PRE-PLANNING DESIGN STATEMENT

PROPOSED NEW DWELLINGHOUSE AT
68 MAZE GREEN ROAD, BISHOPS STORTFORD, CM23 2PL
PREPARED: JAN 2024

Application No. 3-22-1927-FUL
Schedule of Reasons for Refusal

No. 438 - PL 101B
REV. B

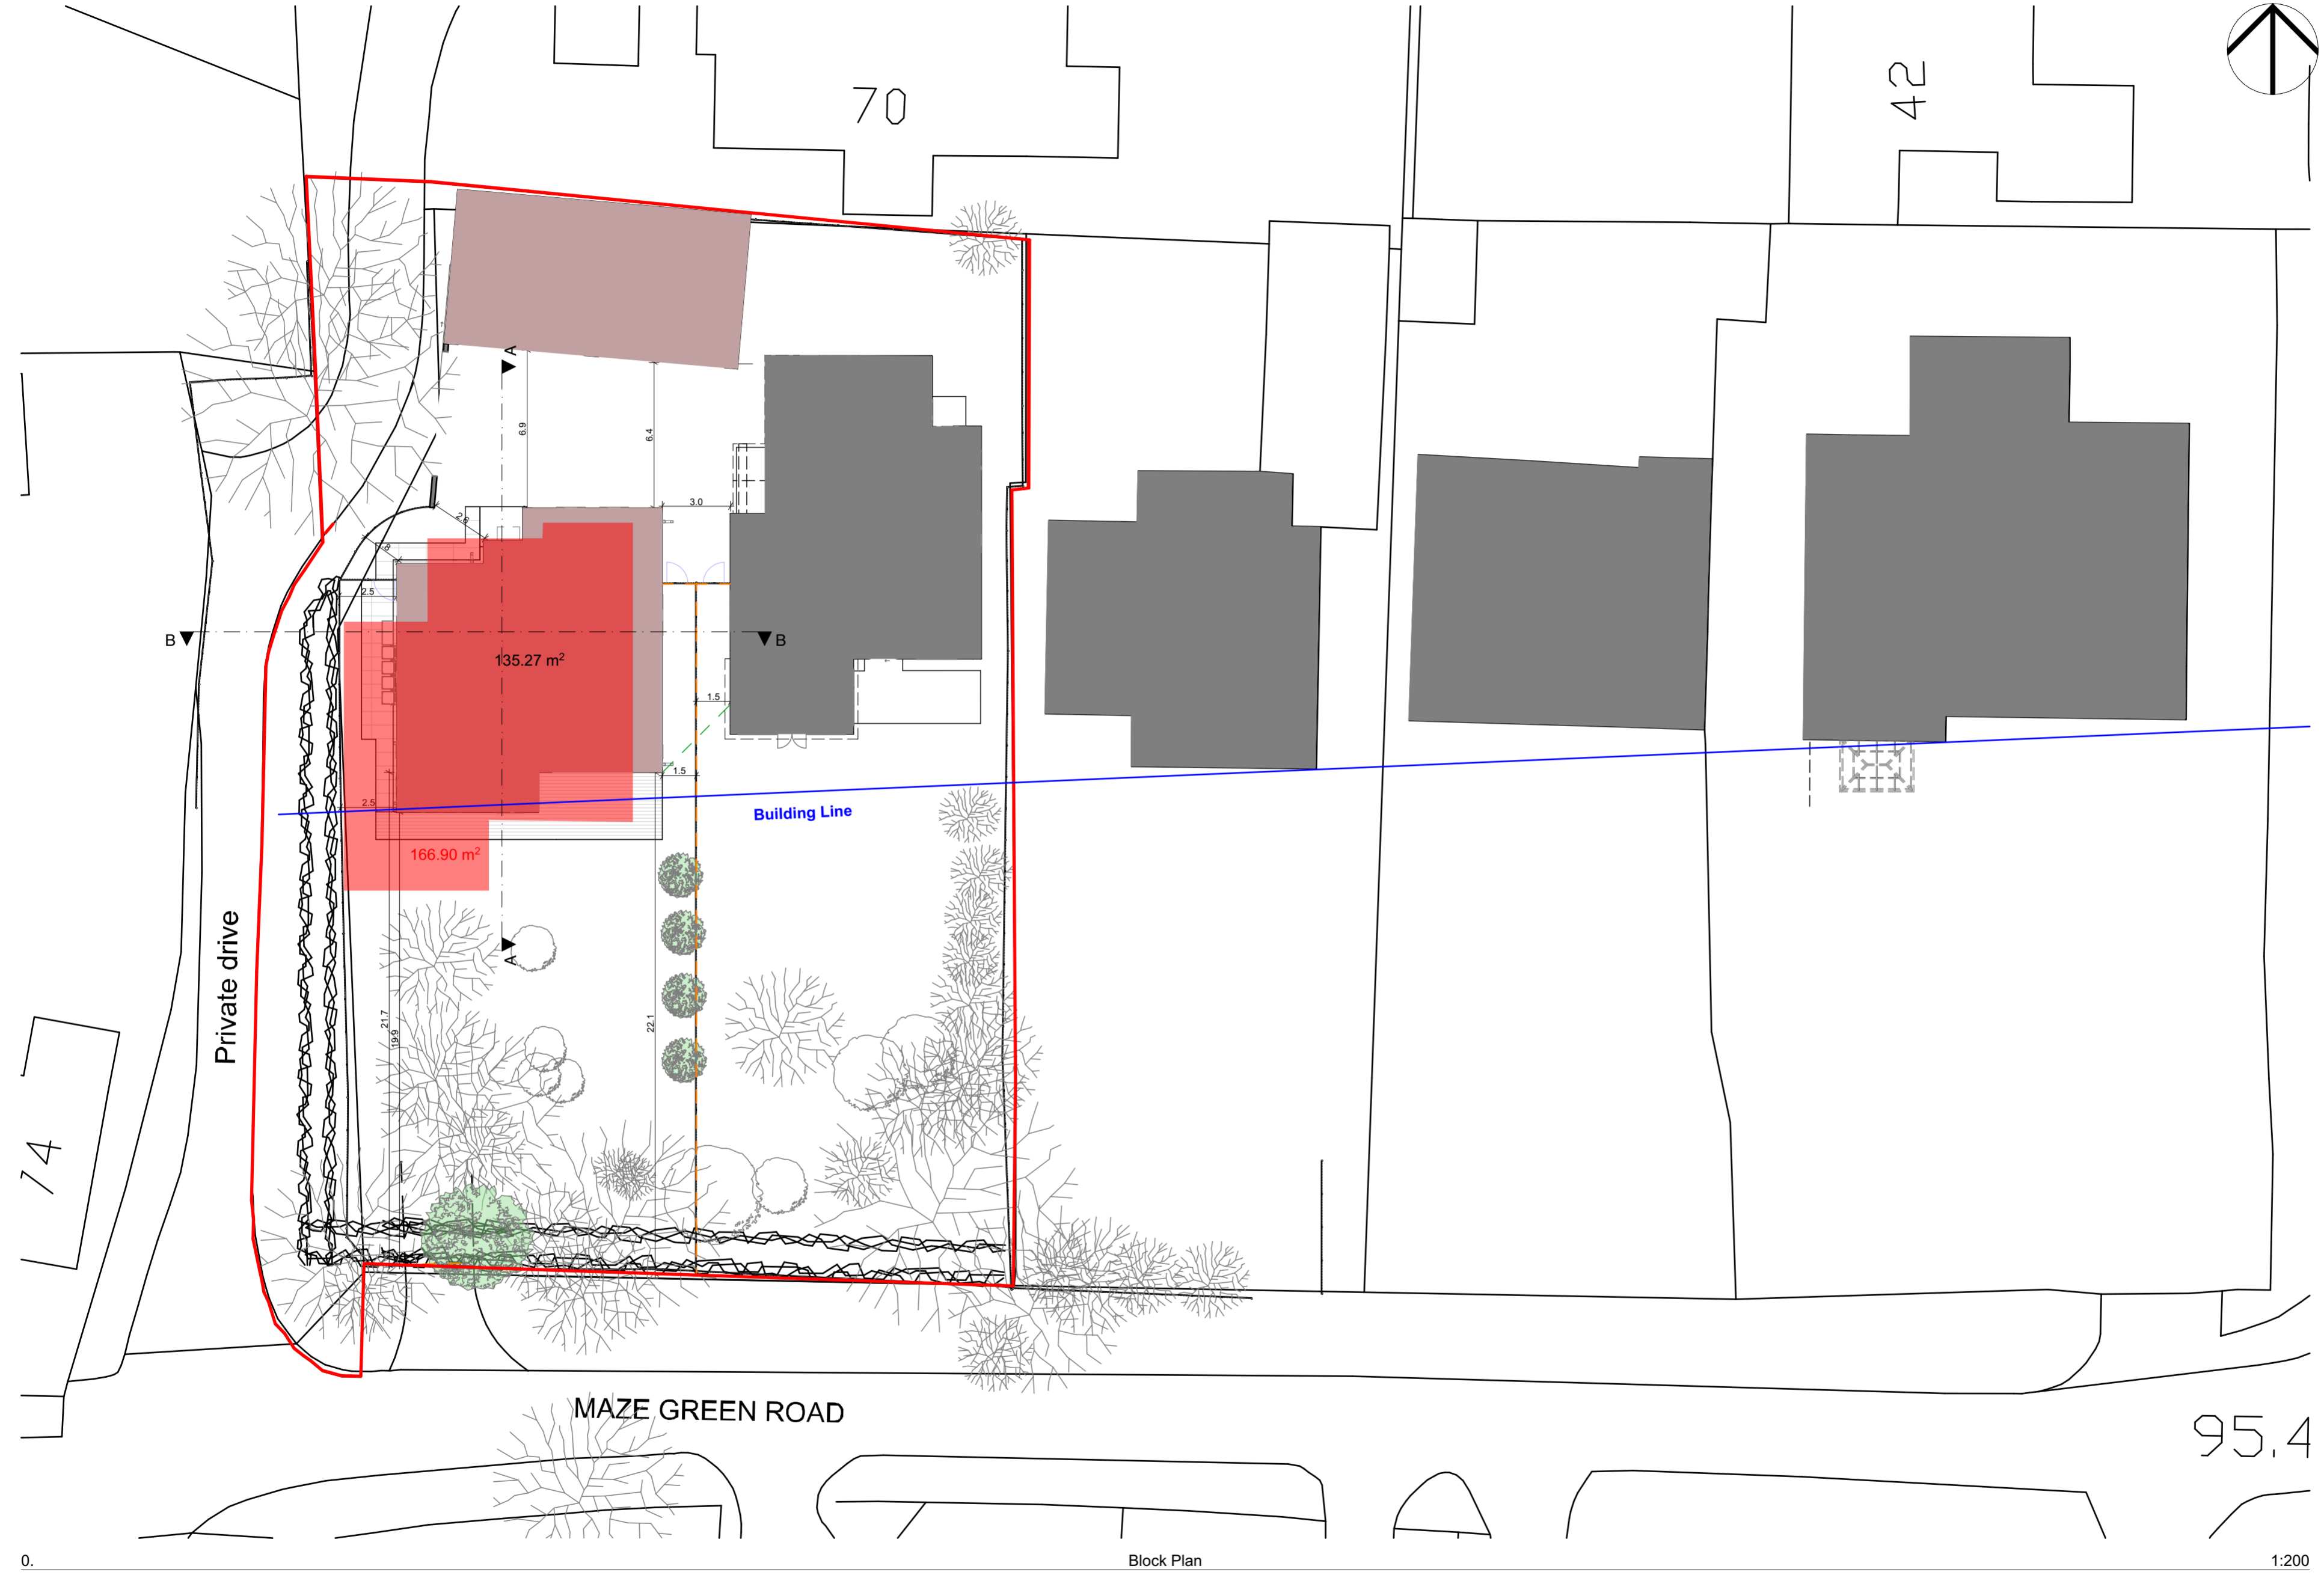
- The position of the house on the site has been amended to better align with the neighbouring properties in the row and the existing building line as noted on drawing 438 - PL 101B Proposed Block Plan (opposite),
